**Consultation Response from KC,  
Lead Local Flood Authority**

**2023/92966 Land to the rear of, 271, Cliffe Lane, Gomersal, Cleckheaton, BD19 4SB**

**Demolition of existing dwelling and erection of 87 dwellings including formation of a new access from Cliffe Lane, landscaping, public open space and all associated infrastructure and engineering works**

**Date Responded: 4<sup>th</sup> July 2024**

Drawing title **PROPOSED LEVELS OPTION 2**

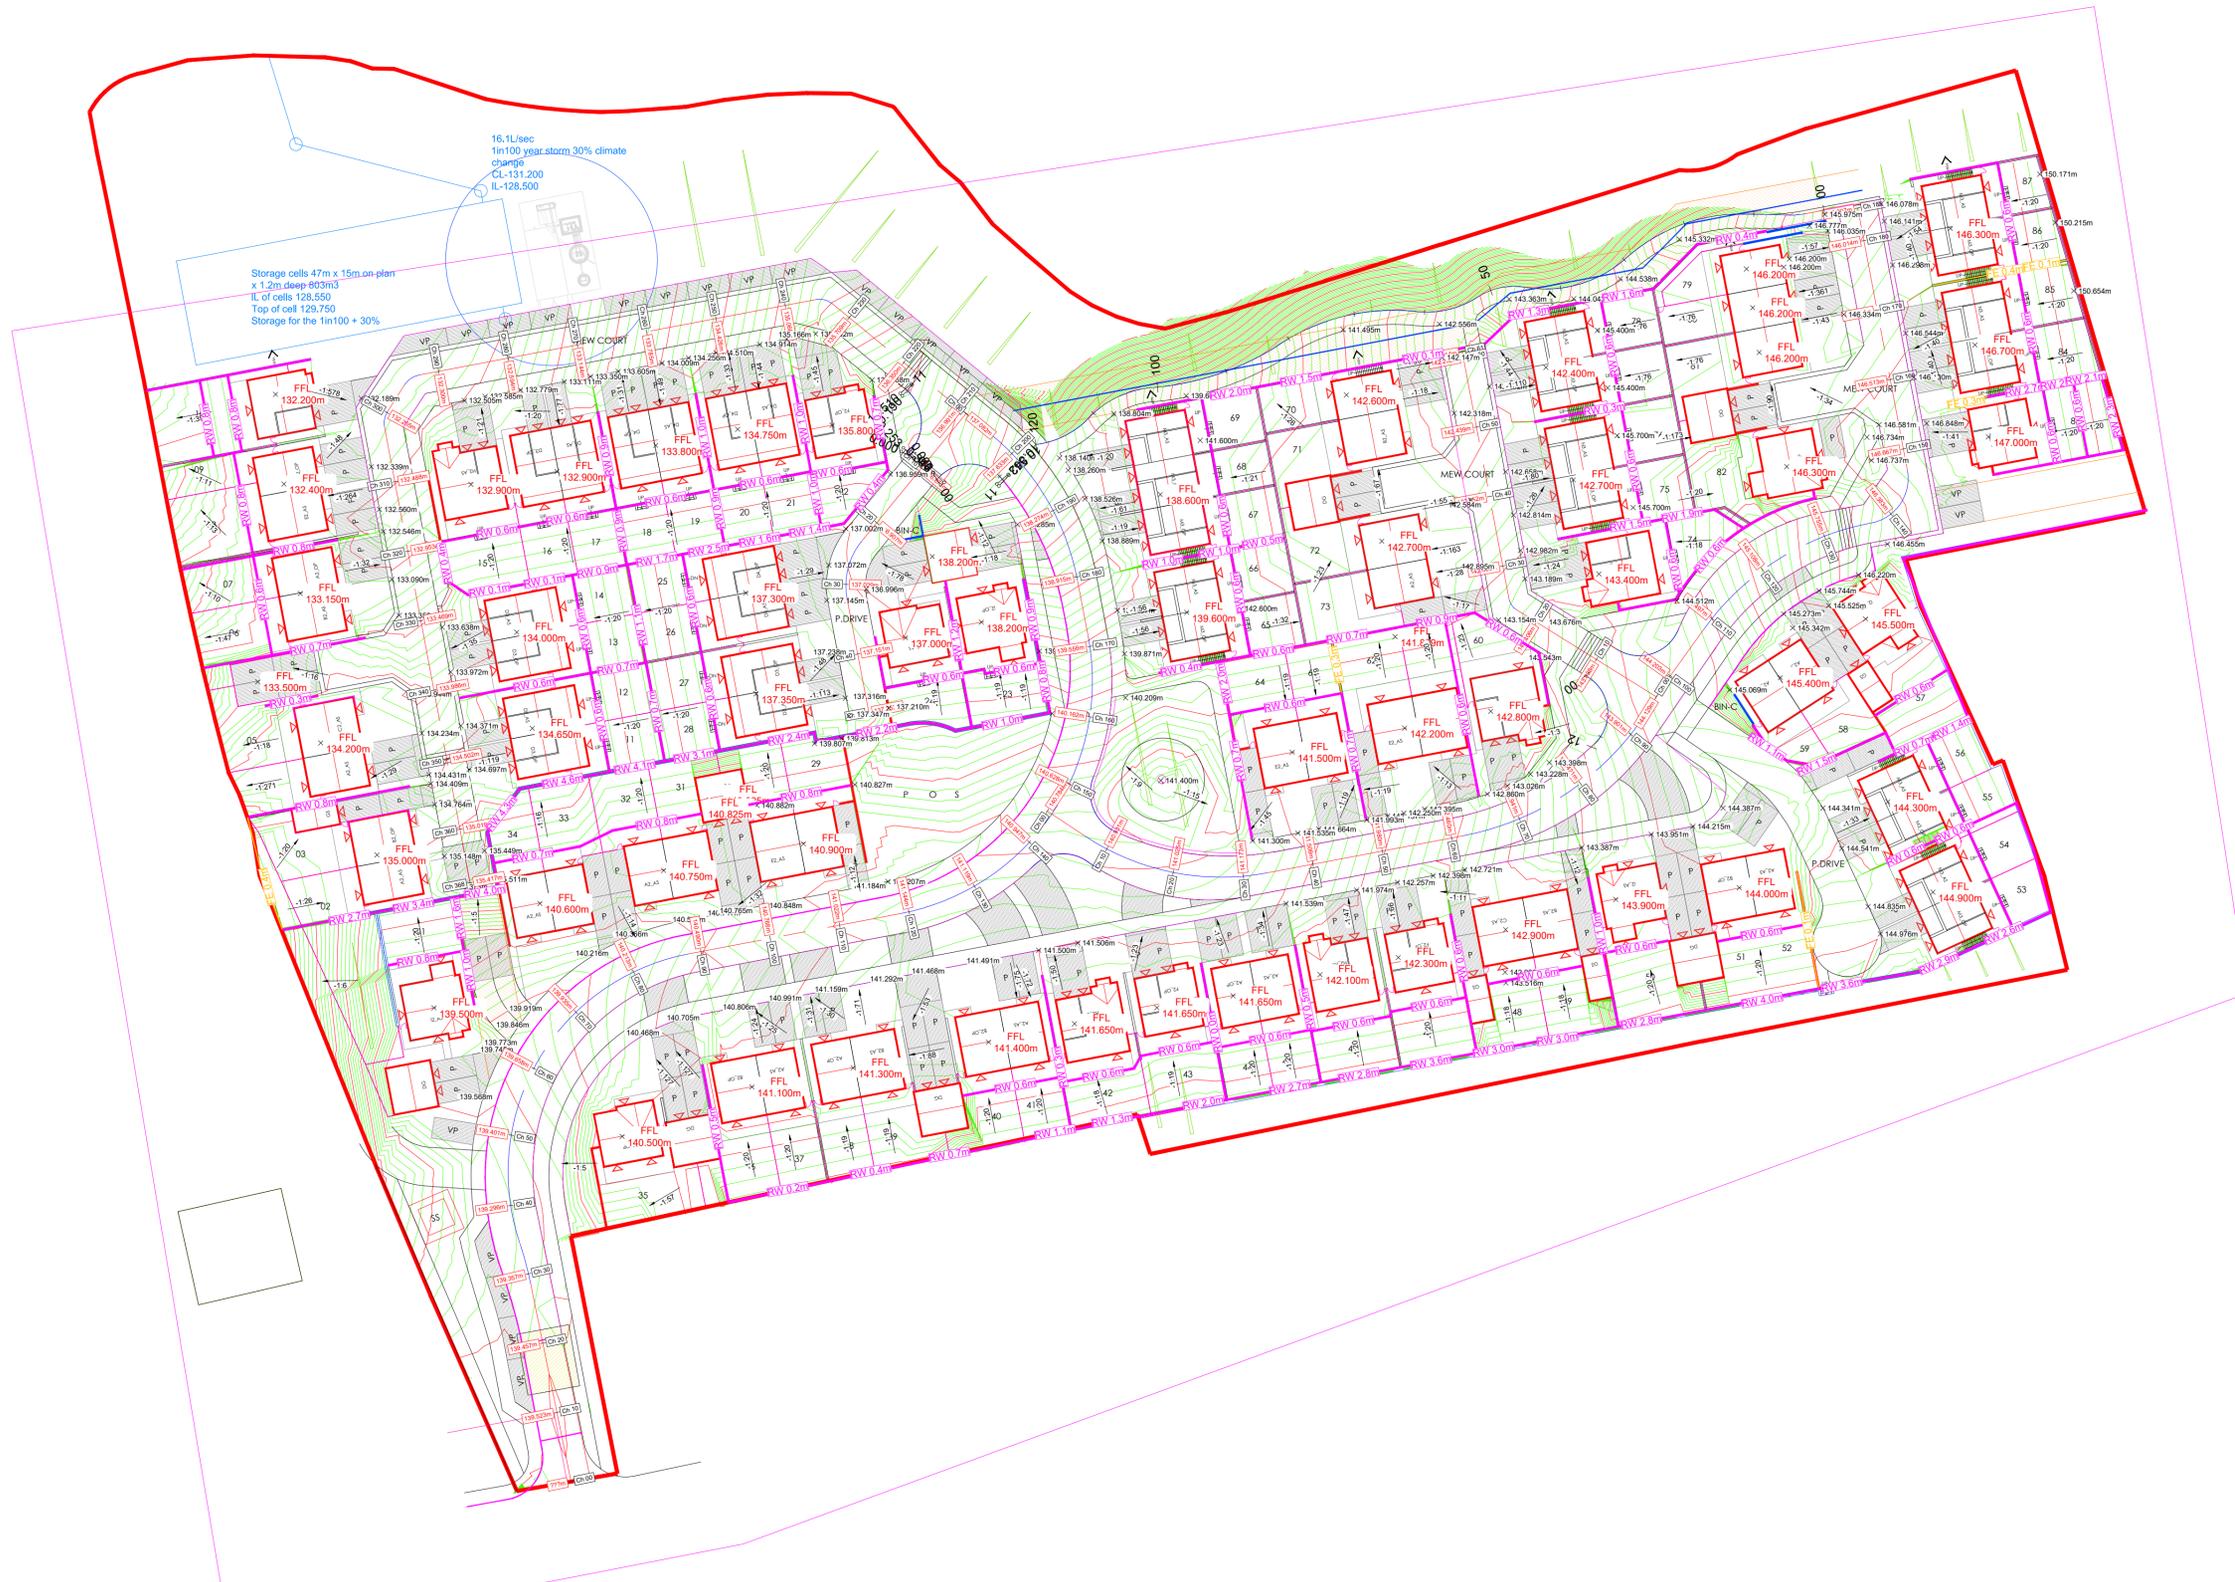
A boundary drawing ref 1694-120 Rev D, showing some levels on roads and plots has been updated with types and heights of boundaries. This is causing great concern as it has been updated yet indicates there will be no change to flood routing that will affect plot 1 and plots 70/71 and potentially plot 10. This will continue to result in an **OBJECTION** for the LLFA as unnecessary flood risk introduced by the design.

Client Quarters Gomersall			
Project Cliffe Lane Gomersall			
Drawing title Drainage Strategy - On Site			
Drawn RT	Chkd	Date FEB 24	Scale 1/500
Contract No. 23054-C-DR	Drg No. 0100	Revision P4

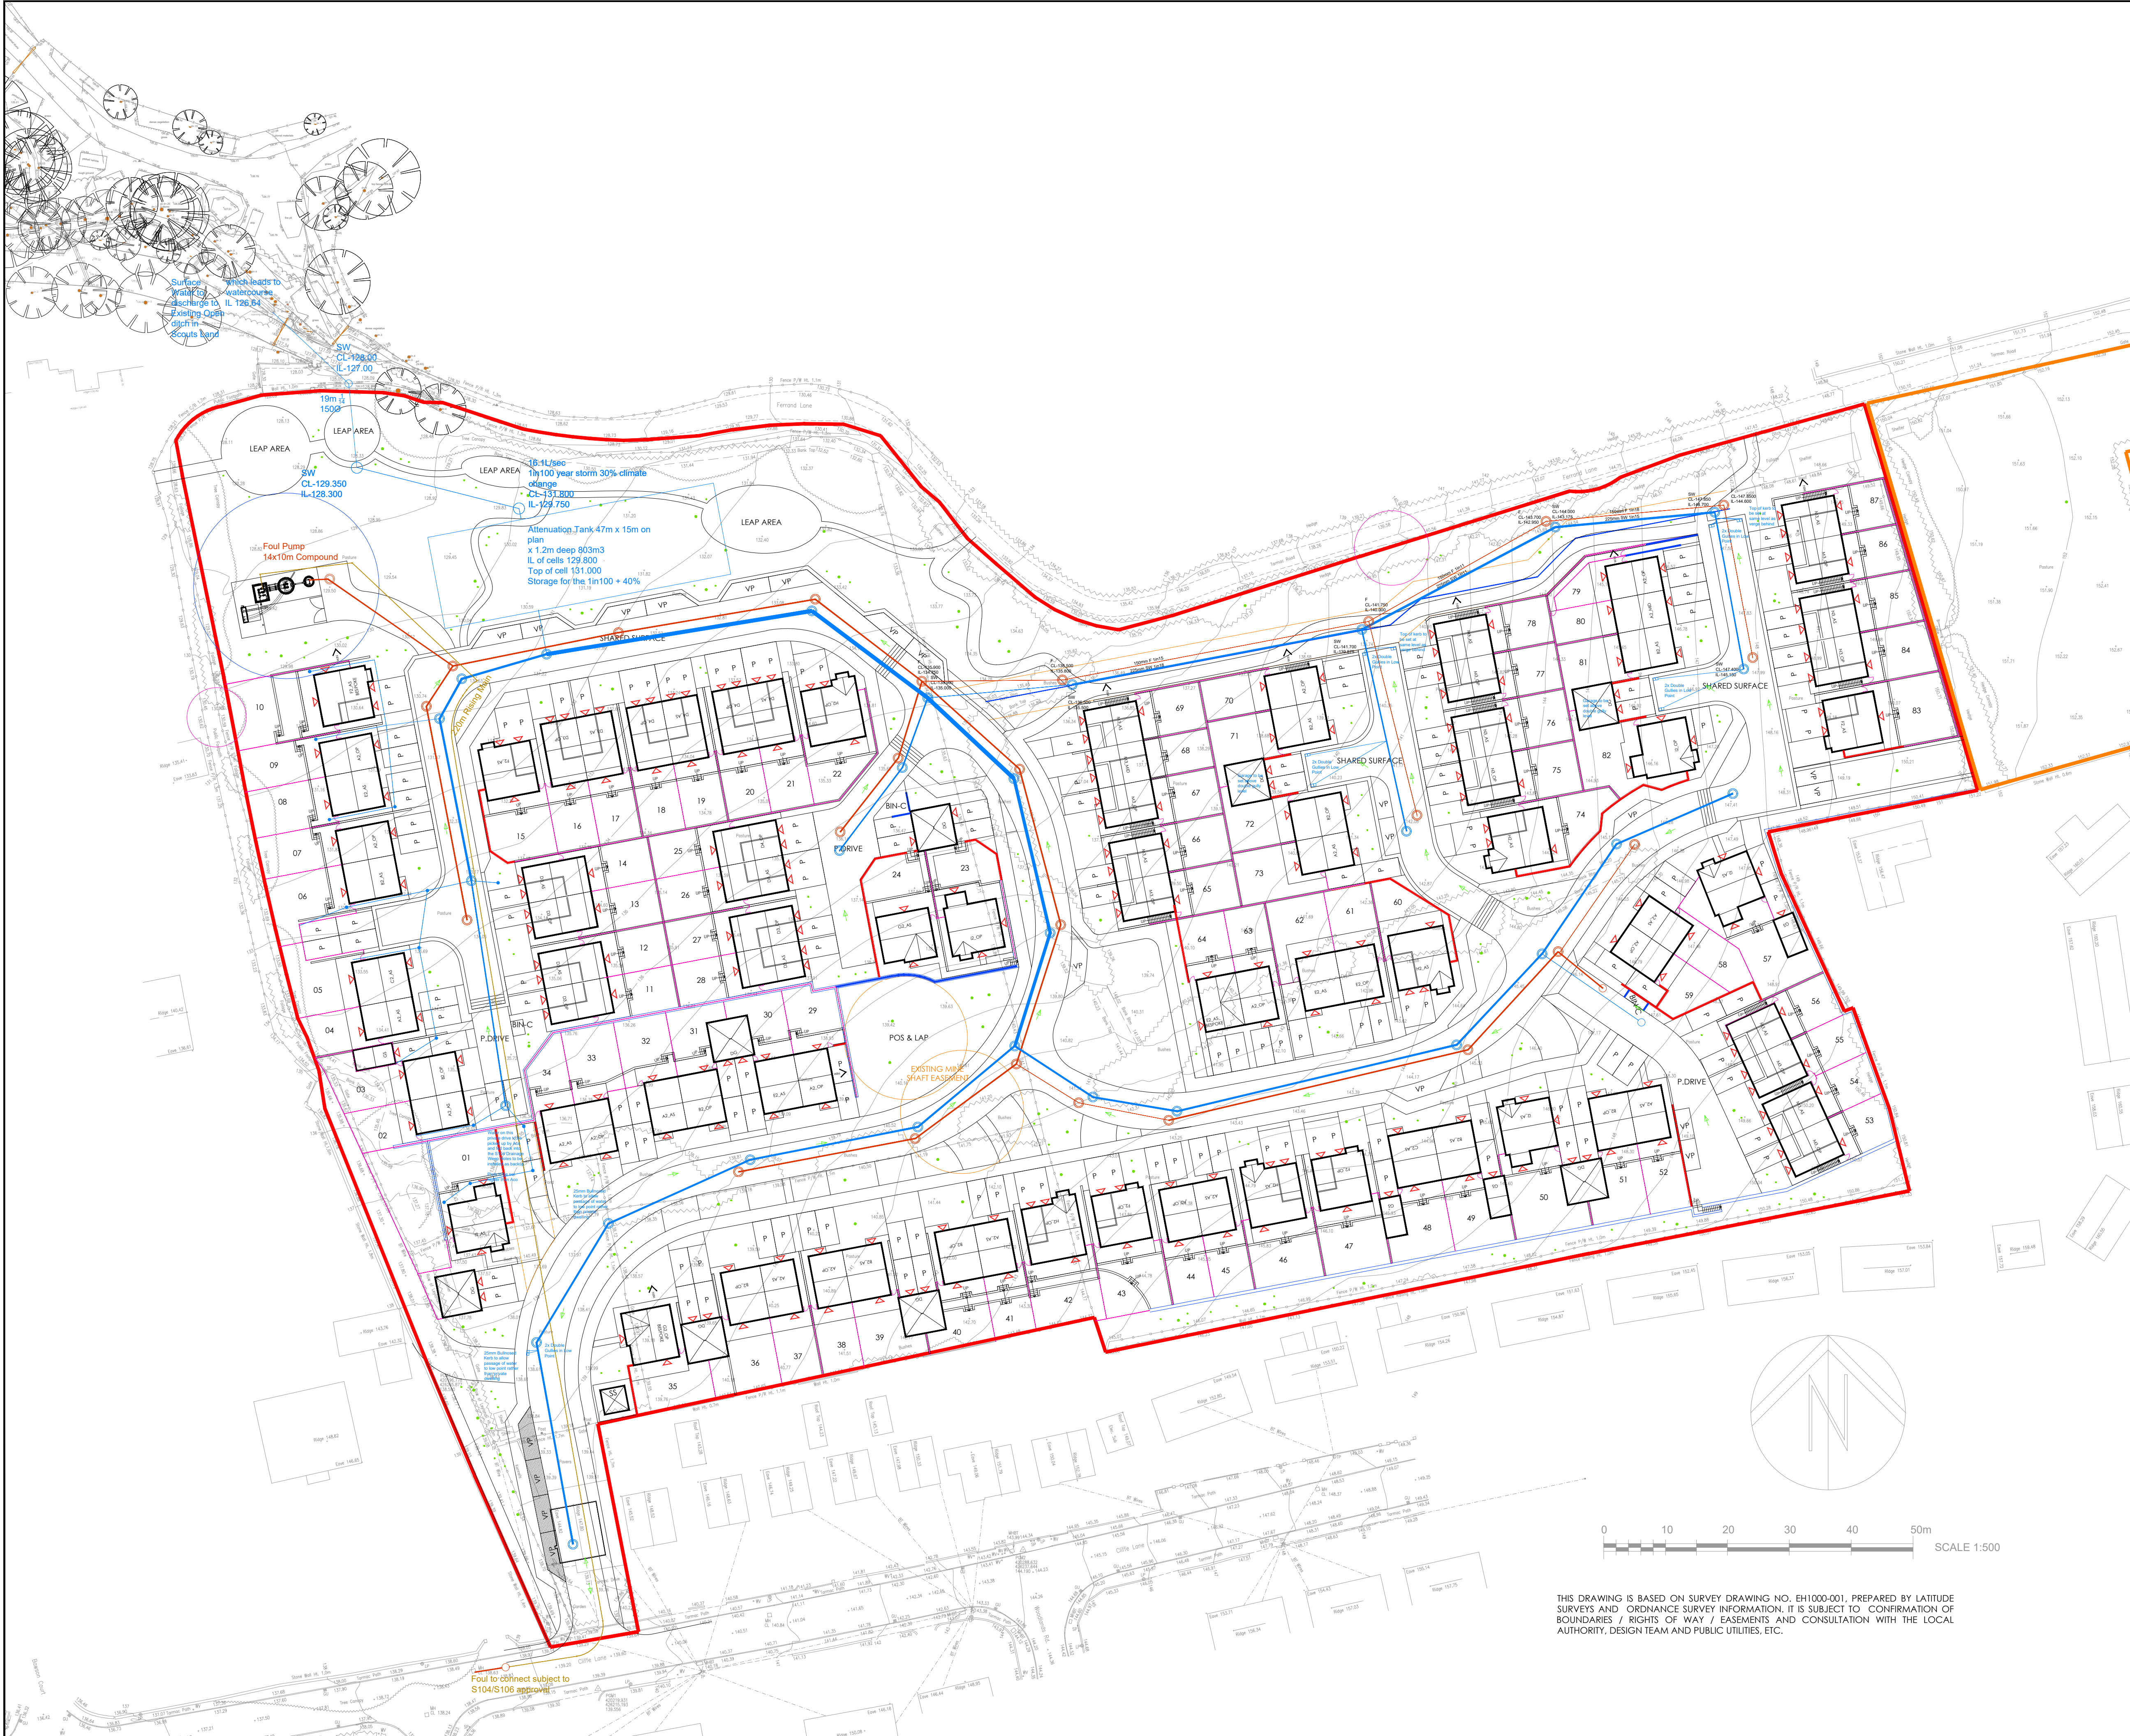
Remaining points regarding off site drainage routes, surveys, and connections, permeable pavement contributions to run off where soakaways are deemed not to work, crate storage attenuation and management thereof, and treatment of surface water discharge are yet to be addressed.
